**Rolling Thunder Business Park, Peak Gymnastics, PPR-18-035**

Please accept the following comments from El Paso County Public Health regarding the project referenced above:

GRADING & EROSION CONTROL PLAN
PEAK GYMNASTICS
JOB NO. 44-032
DATE PREPARED: DECEMBER 5, 2018
DATE REVISED:

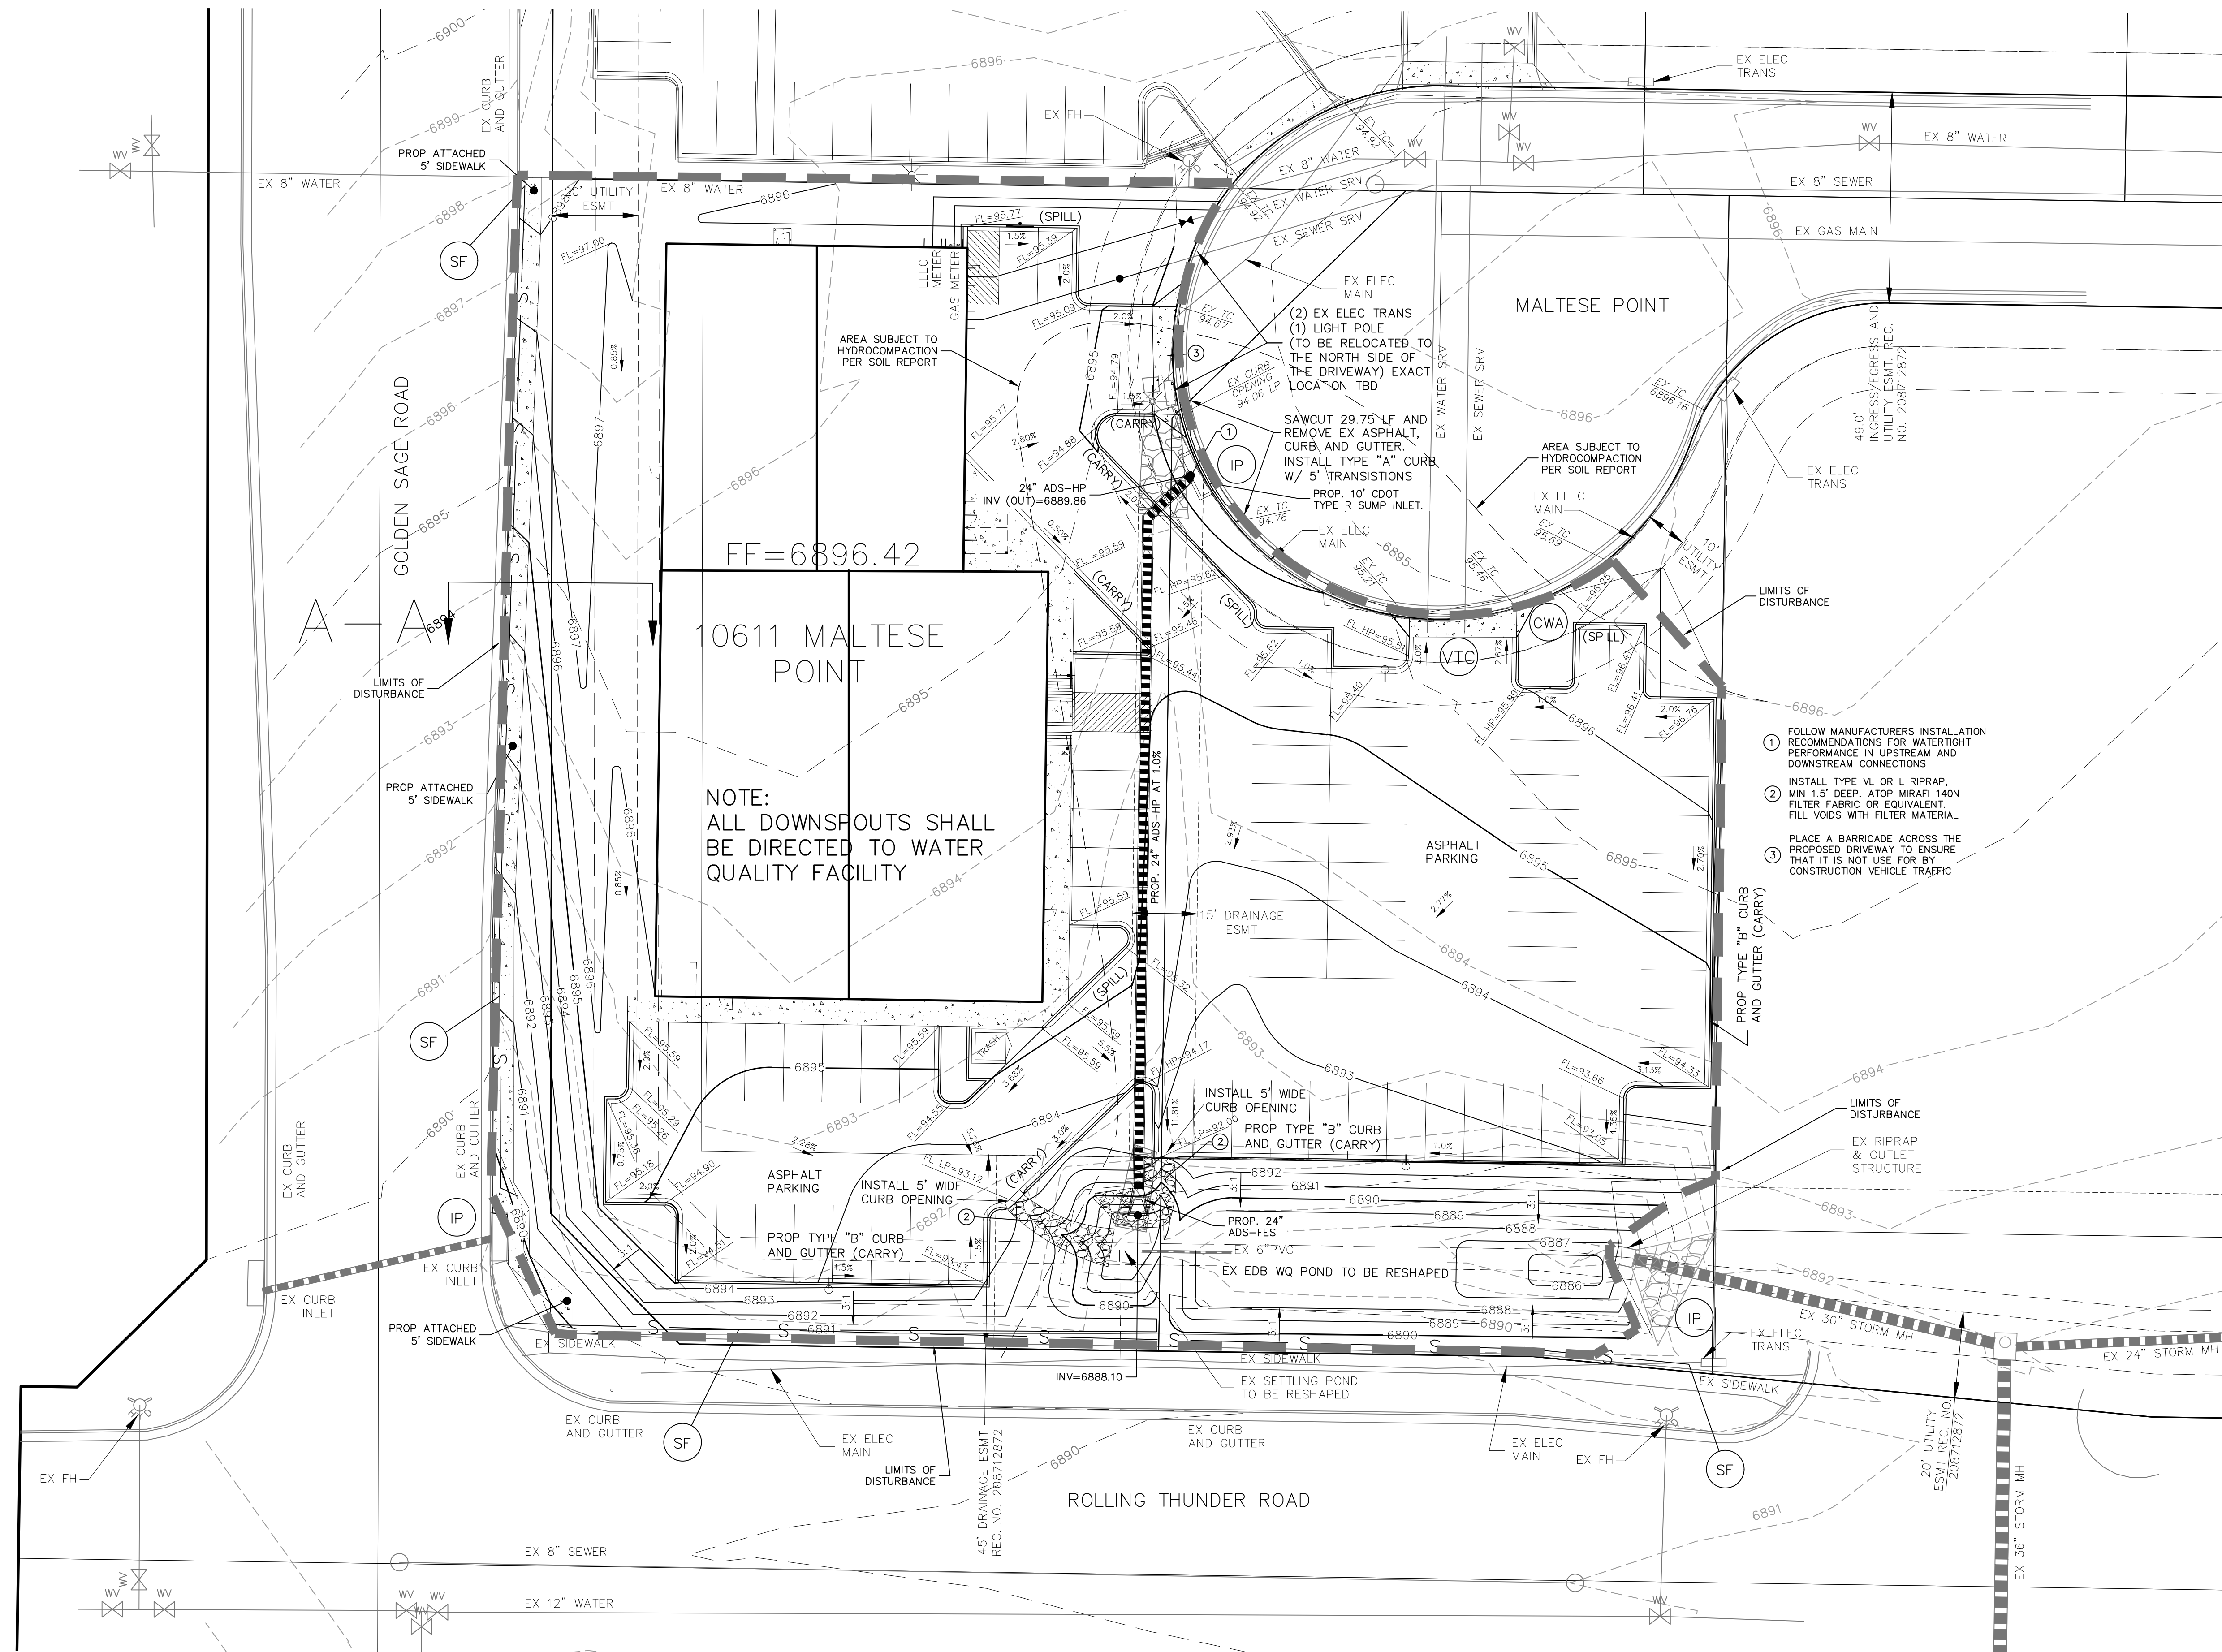
- The water quality detention basins must have mosquito control responsibilities included as a part of the maintenance plan and/or the design to help control mosquito breeding habitat and minimize the potential for West Nile Virus.
